K MART Warehouse and Distribution Centre Director-General's Requirements

Application Number	10_0082
Project	The K MART Warehouse and Distribution Centre Project, including the construction, fit out and operation of the warehouse and distribution centre
Location	Wonderland Drive, Eastern Creek 2766, Lot 2/DP1149138
Proponent	Rylehall Pty Ltd
Date of Issue	23 June 2010
General Requirements	<p>The Environmental Assessment of the project must include:</p> <ul style="list-style-type: none"> • an executive summary; • a detailed description of the project, including: <ul style="list-style-type: none"> – existing and approved operations/facilities, including any statutory approvals that apply to these operations/facilities; – the development to be carried out onsite, including plans of all proposed building works; and – the likely staging of the project; • a risk assessment of the potential environmental impacts of the project, identifying the key issues for further assessment; • a detailed assessment of the key issues specified below, and any other significant issues identified in the risk assessment (see above), which includes: <ul style="list-style-type: none"> – a description of the e

DRAWING TITLE  
 NORTH EAST  
 CORNER PERSPECTIVE

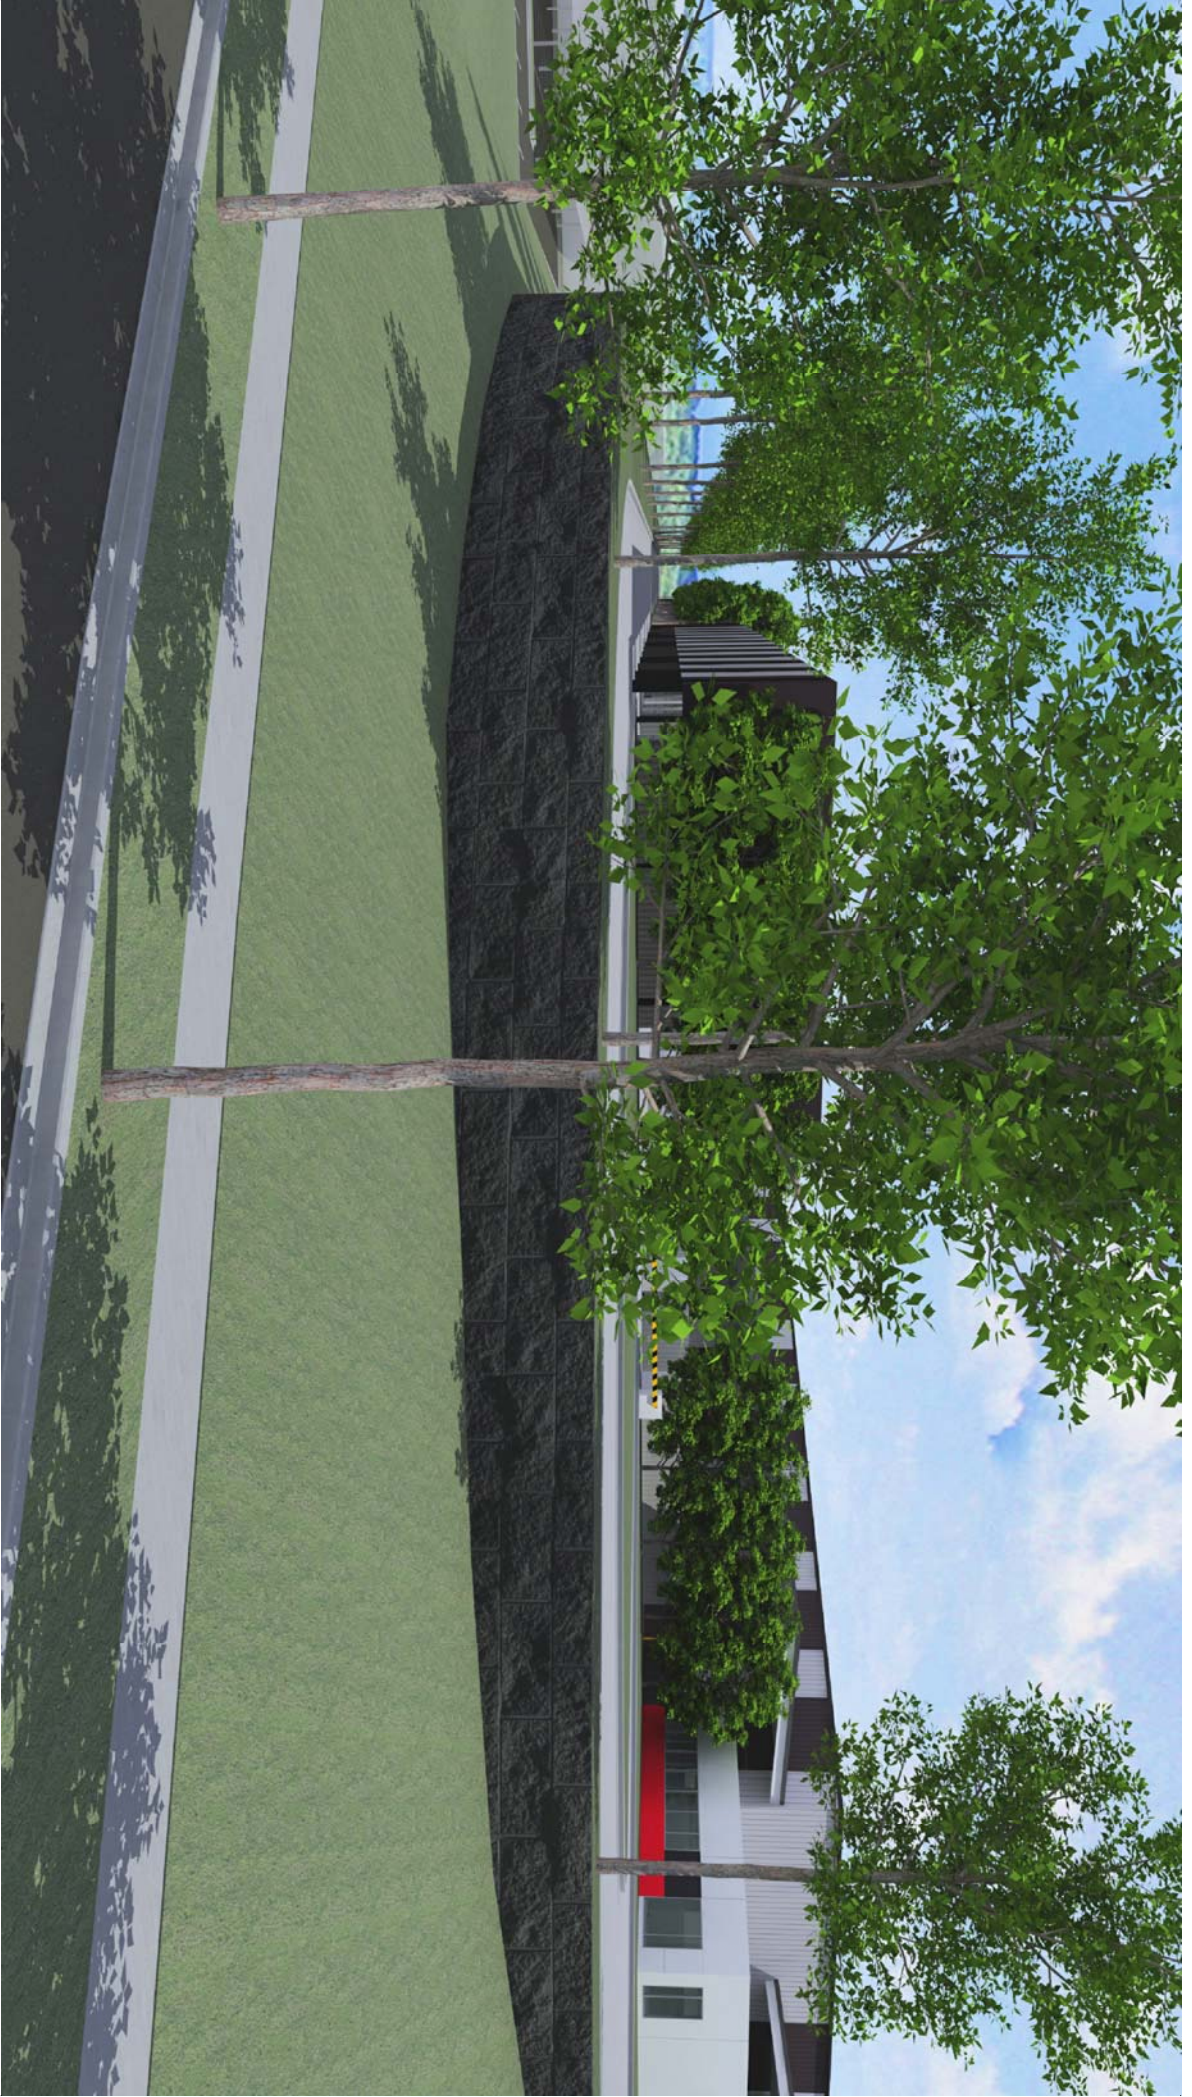
The current photomontage plans do not show any views of the container storage area or its view from the proposed future road to the north east of the site, therefore making it difficult to properly assess its visual impact. Additional photomontage plans should be prepared.

DRAWING TITLE LANDSCAPE MASTER PLAN	
SCALE 1:500 @ B1	
DESIGNED/DRAWN PLJAH	
CHECKED PL	
DATE 07/06/2010	
JOB NUMBER 0138	
DRAWING NUMBER 0138-01	ISSUE C

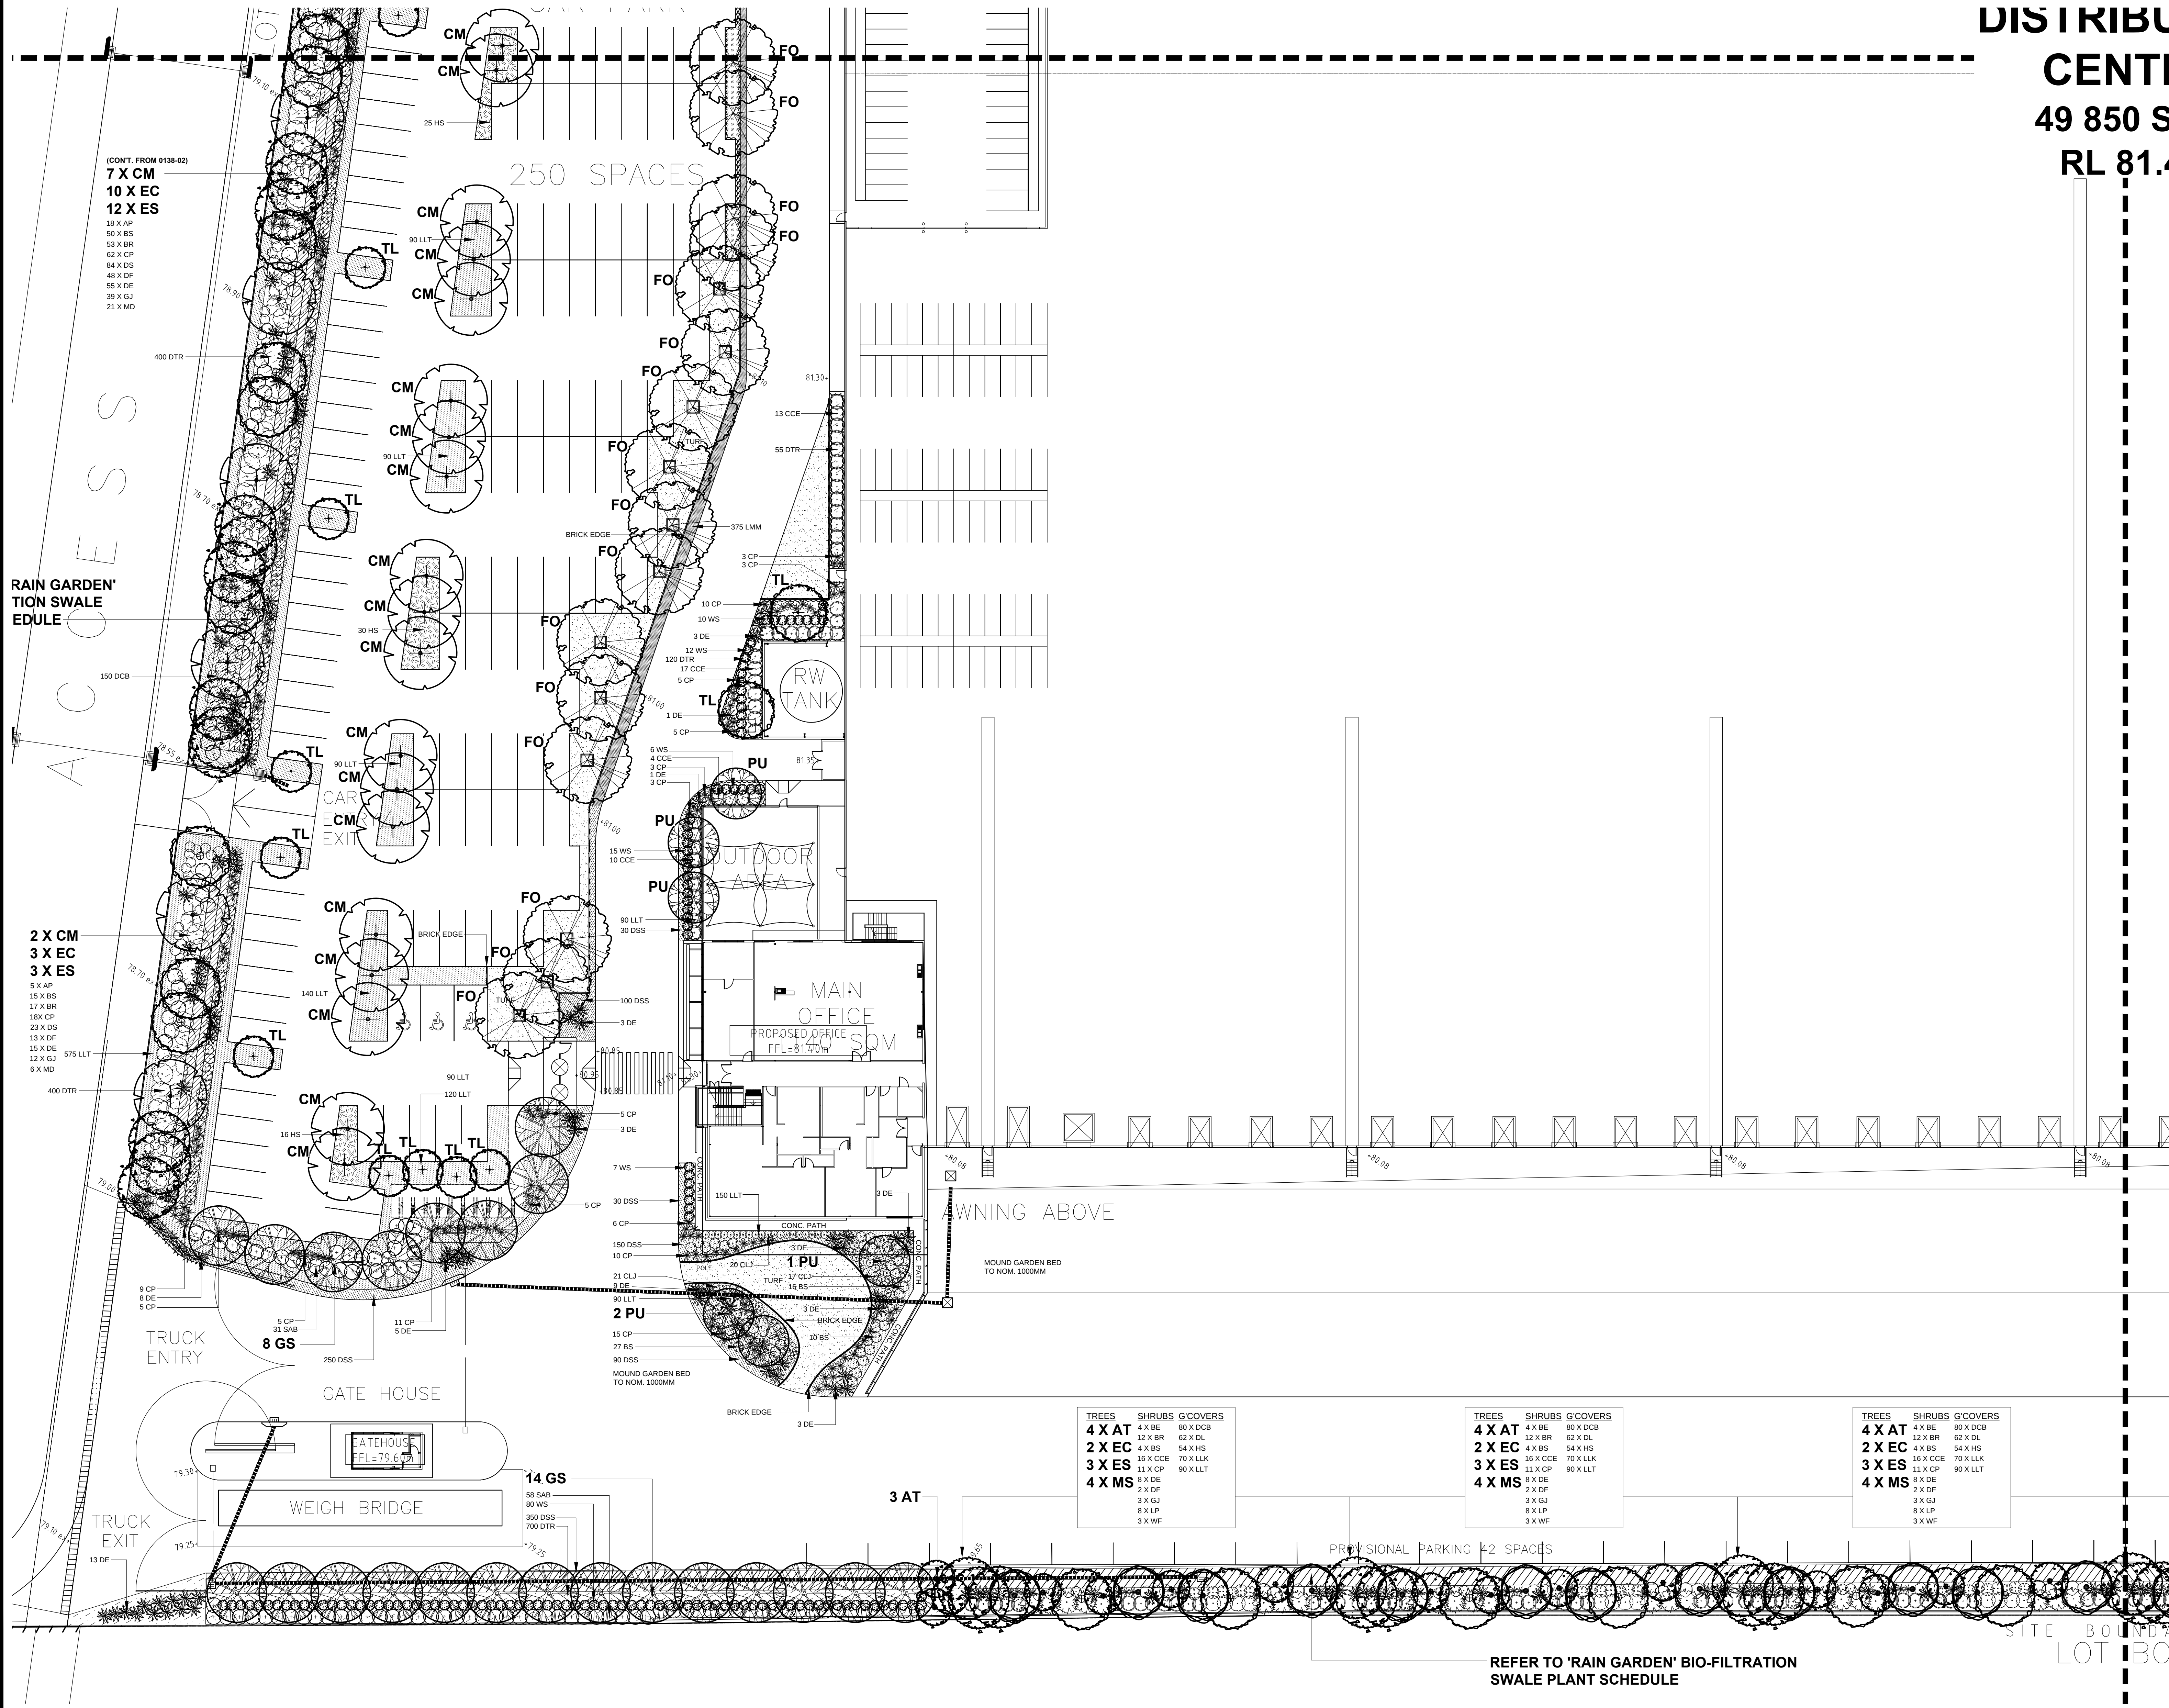
Further, irrespective of the height of the containers additional screening should be included for the full length of the eastern boundary and include dense landscaping in an effort to conceal the containers and storage area.

Council requests that any landscaping strategy include a variety of suitable ground covers, shrubs and trees to complement the height, scale, design and function of the development by providing a variety of species which are endemic to the locality.

The landscaping plans should also consider measures designed to enable easy long-term maintenance of the property and a planting of a combination of 35 litre, 75 litre and 100 litre trees. All shrubs to be planted are to have a minimum pot size of 200mm.
